Comments on the Applicant's D5 Submissions

This document sets out the comments on the Applicant's Deadline 5 (D5) submissions by Cambridgeshire County Council (**CCC**). The tables below set out the document in question that the Council is commenting on, together with the relevant paragraph or reference number.

6.2 Appendix 13C Framework Construction Traffic Management Plan and Travel Plan (Tracked) - Rev: 04 [REP5-015] and all Appendices (A to G) [REP5-016 to REP5-042]

ACM-60589004-AMR-DR-0039

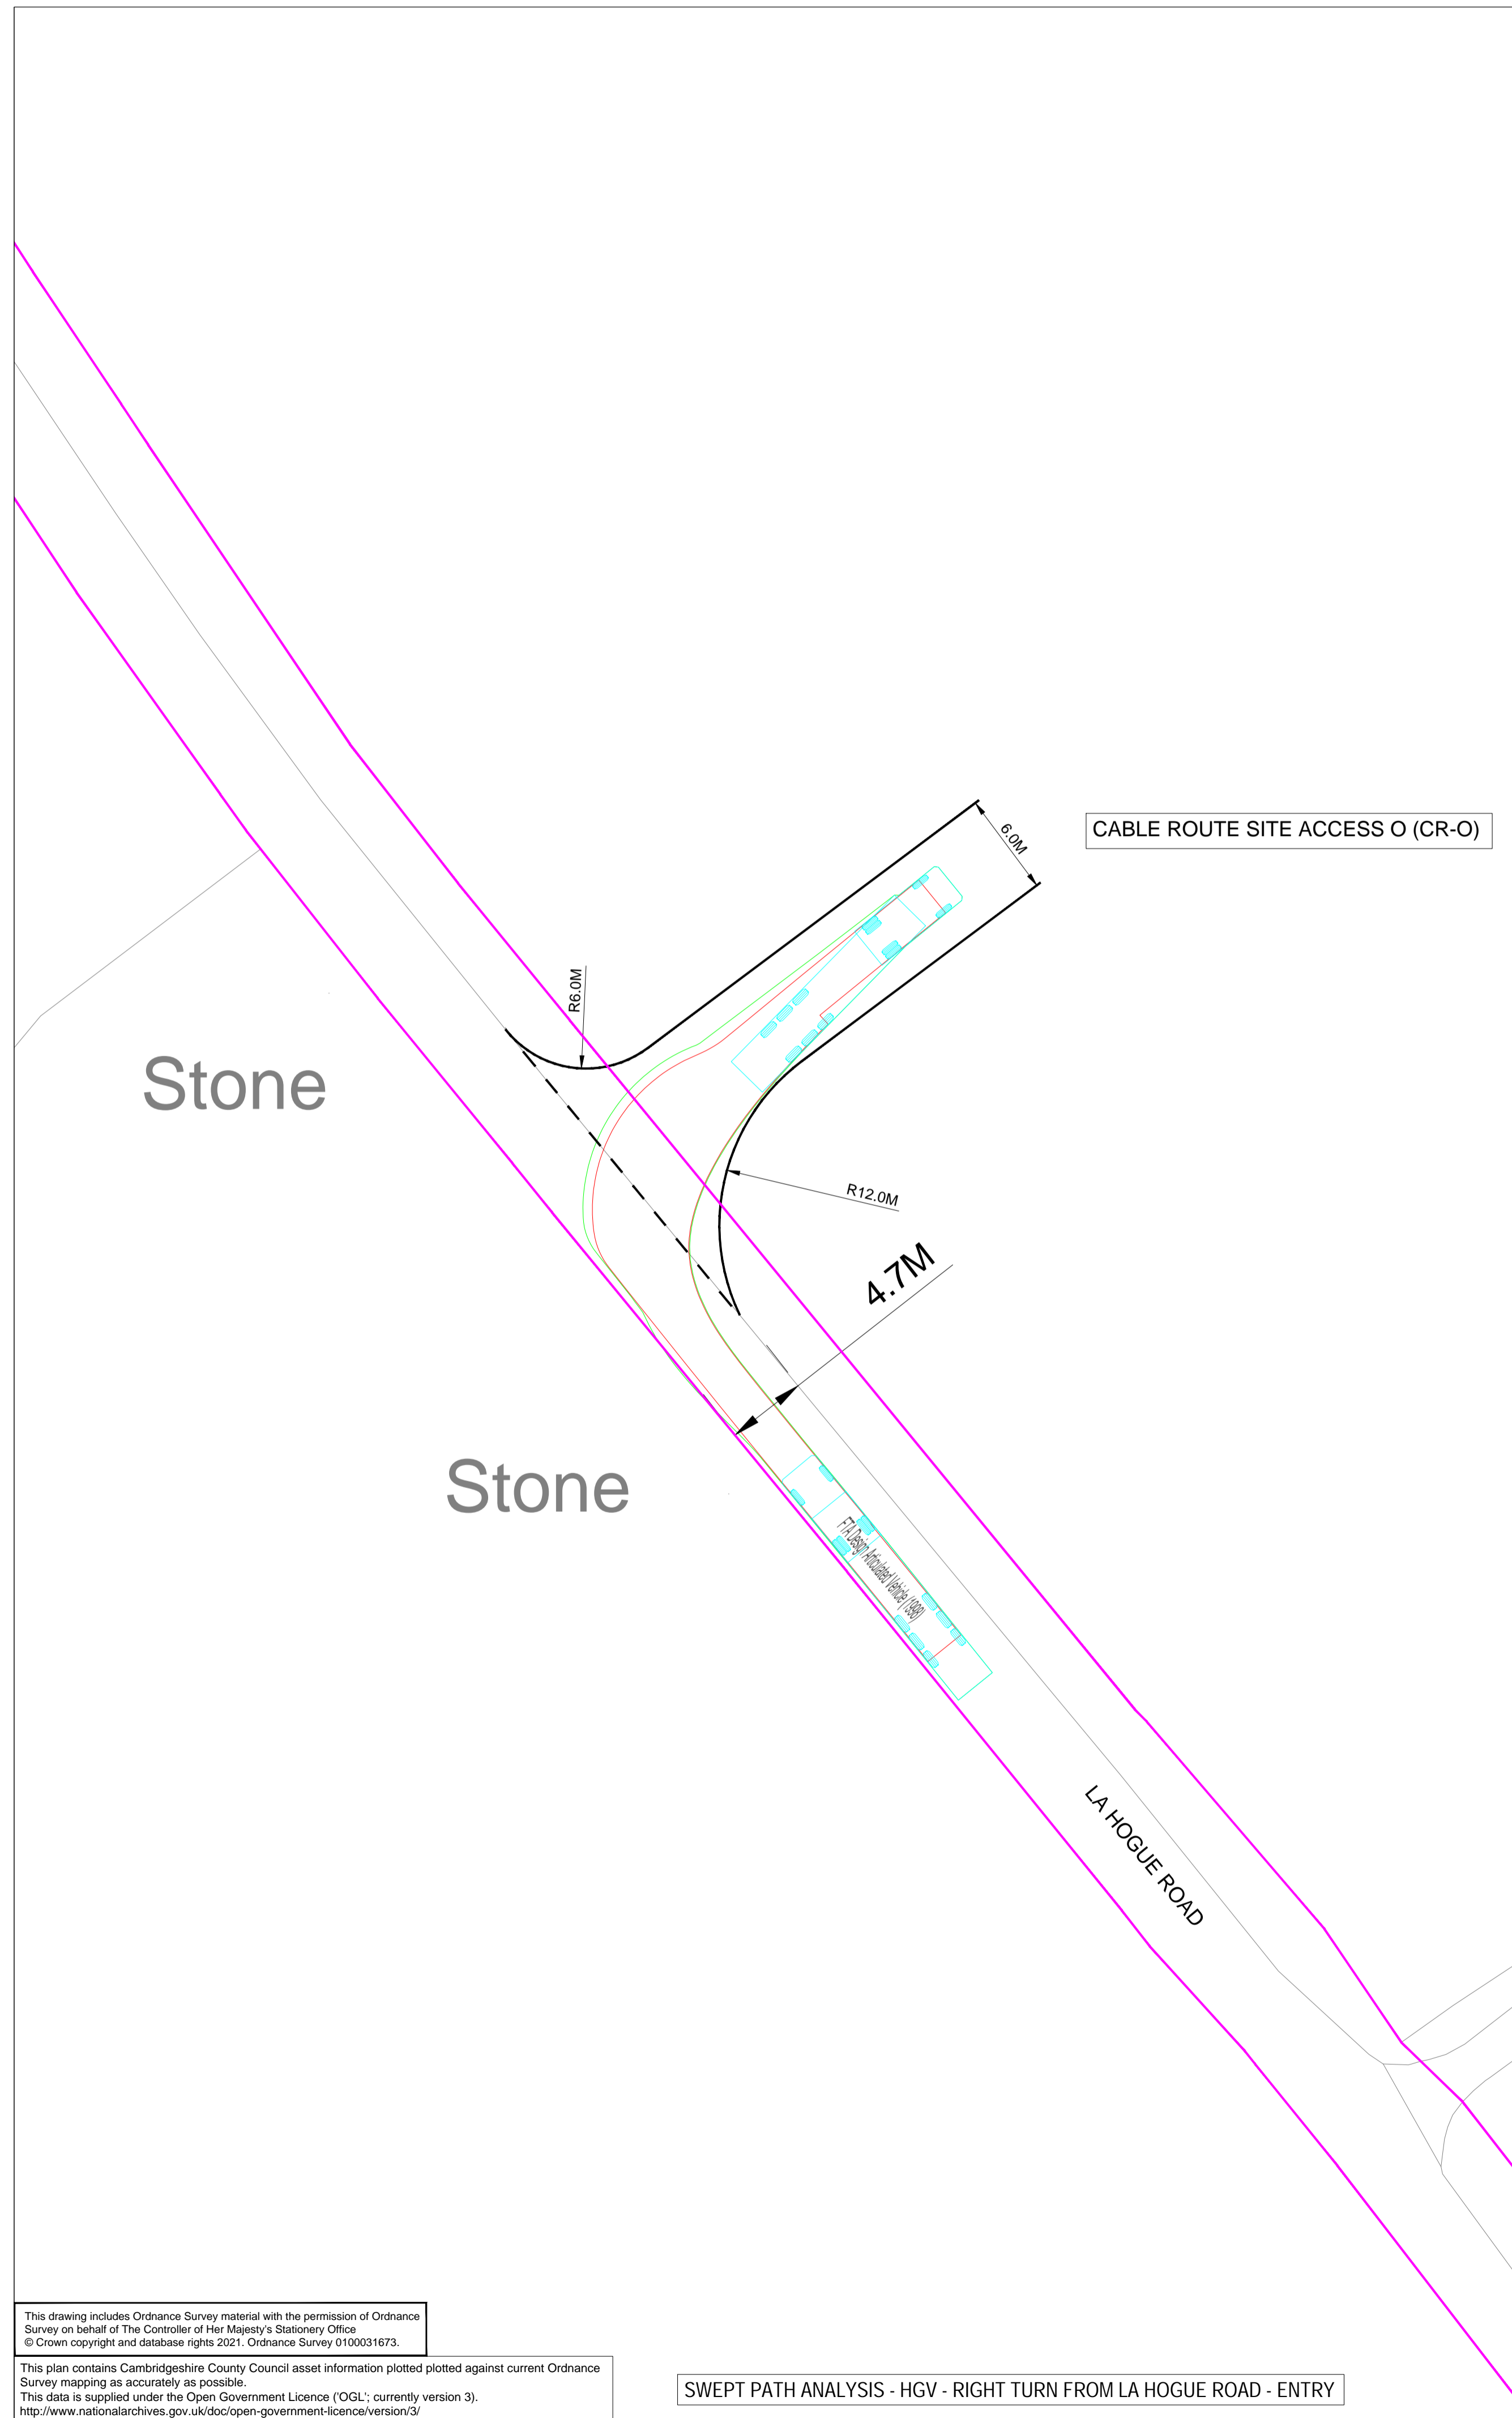
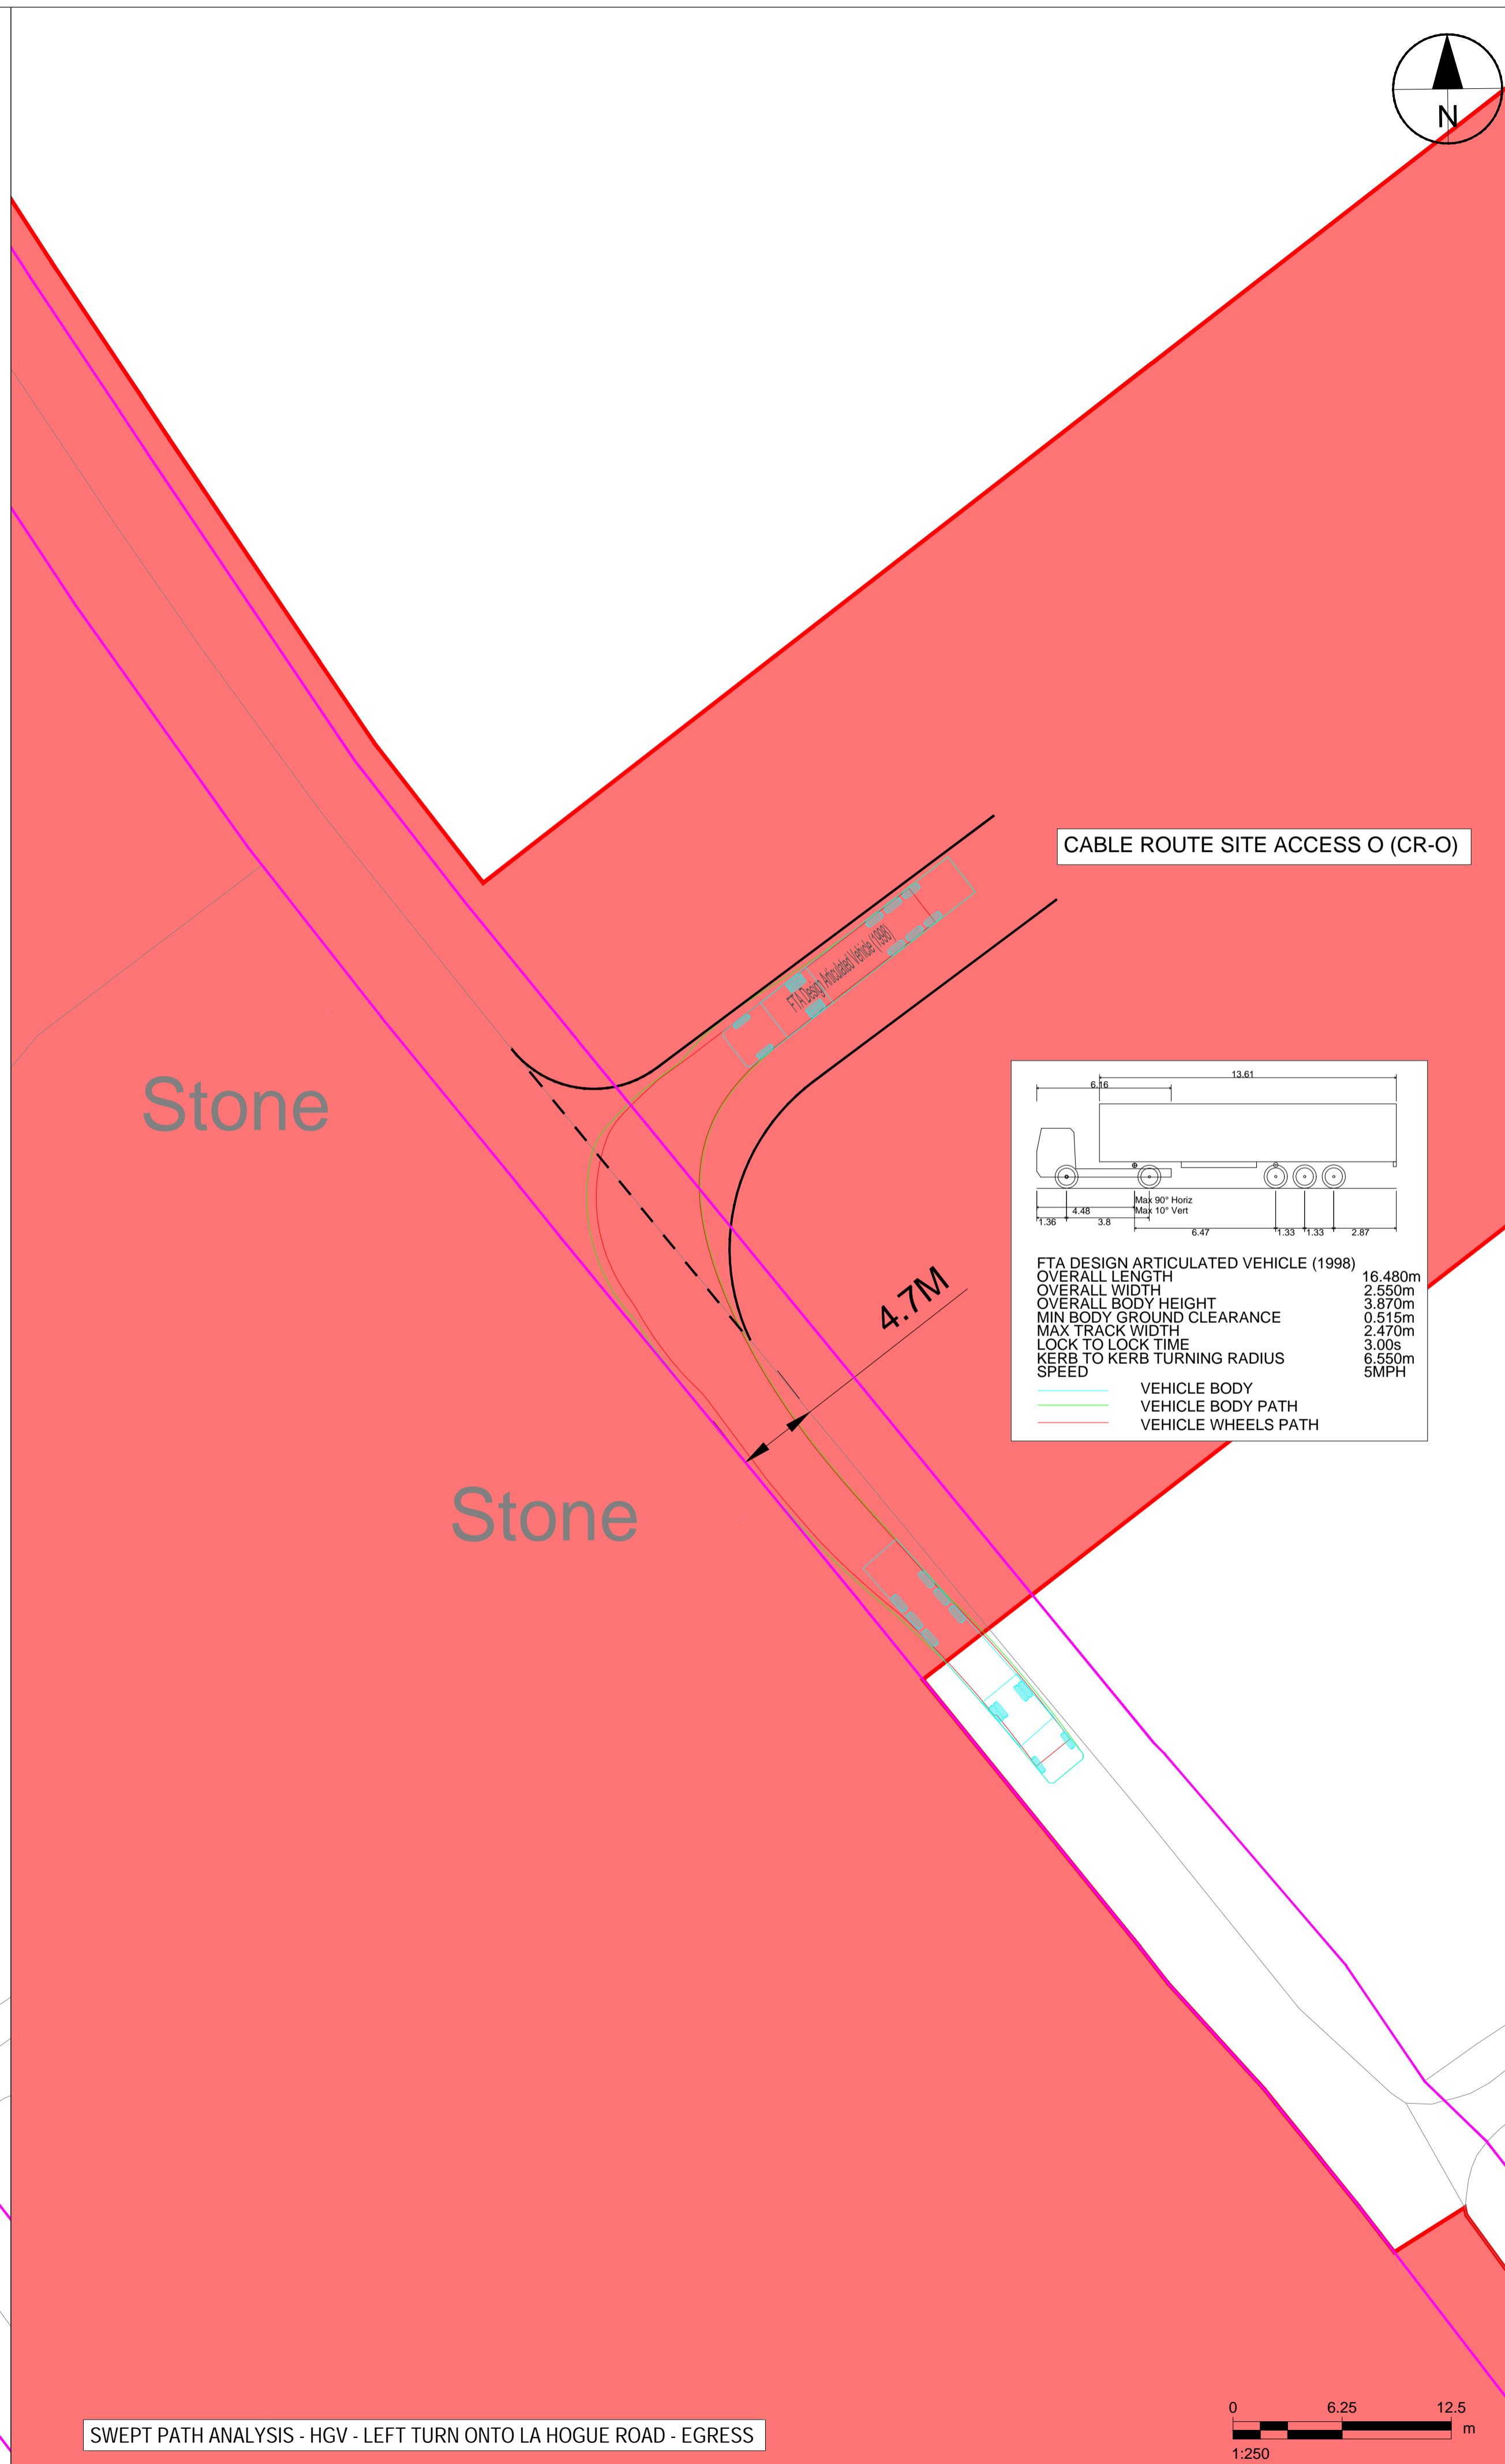
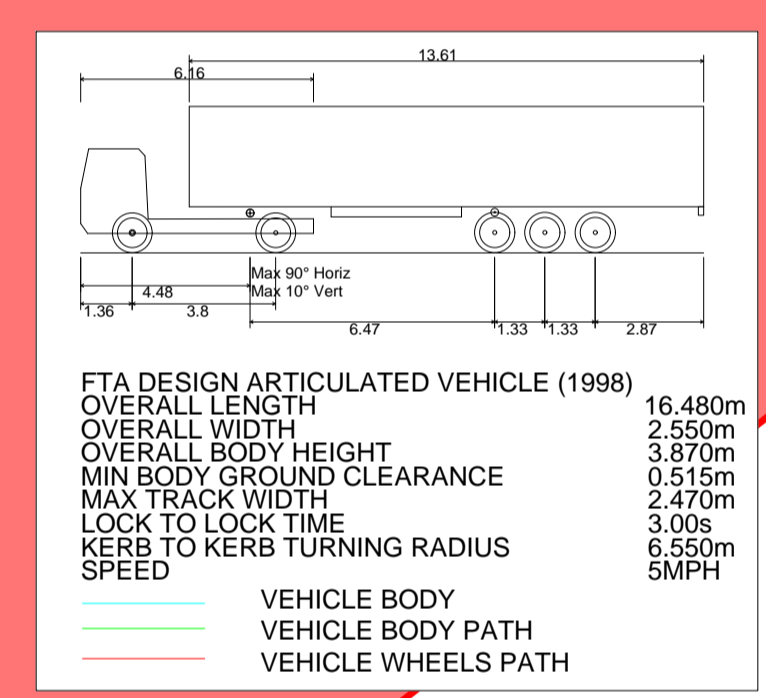
Plan ACM-60589004-AMR-DR-0039/-0040	Cable Route Access P. B1085.	<p>The proposal is to utilise an unmade field access, with improvements proposed, including 14m radius to the east and 6m radii to the west.</p> <p>The swept path detail shown does not demonstrate the ability for two vehicles to pass, and while movement will be managed by traffic signals during the construction phase, it is unclear how the access will be used during the operational phase, or how such conflict will then be managed. It is therefore unclear whether safe access is provided.</p> <p>No visibility splays have been detailed to demonstrate that visibility appropriate to the speed of the road can be achieved within the DCO or Highway boundary. The highway is bounded by a dense hedgerow to the west and trees to the east, both of which are close the road edge; It appears unlikely that suitable visibility can be achieved without significant removal of trees/hedge to allow safe uncontrolled access and it is not therefore possible to</p>

confirm that safe access can be achieved during the operational phase in the absence of traffic management.
Plan ACM-60589004-AMR-DR-0039/-0040	Cable Route Access Q. B1085.	<p>The proposal is to utilise an existing field access, with improvements proposed, including 14m radius to the east and 6m radii to the west.</p> <p>The swept path detail shown does not demonstrate the ability for two vehicles to pass, and while movement will be managed by traffic signals during the construction phase, it is unclear how the access will be used during the operational phase, or how such conflict will then be managed. It is therefore unclear whether safe access is provided.</p> <p>No visibility splays have been detailed to demonstrate that visibility appropriate to the speed of the road can be achieved within the DCO or Highway boundary. The highway is bounded by a dense hedgerow to the west and trees to the east, both of which are close the road edge, compounded further by the road to the east bending to the south; It appears unlikely that suitable visibility can be achieved without significant removal of trees/hedge to allow safe uncontrolled access and it is not therefore possible to confirm that safe access can be achieved during the operational phase in the absence of traffic management.</p>
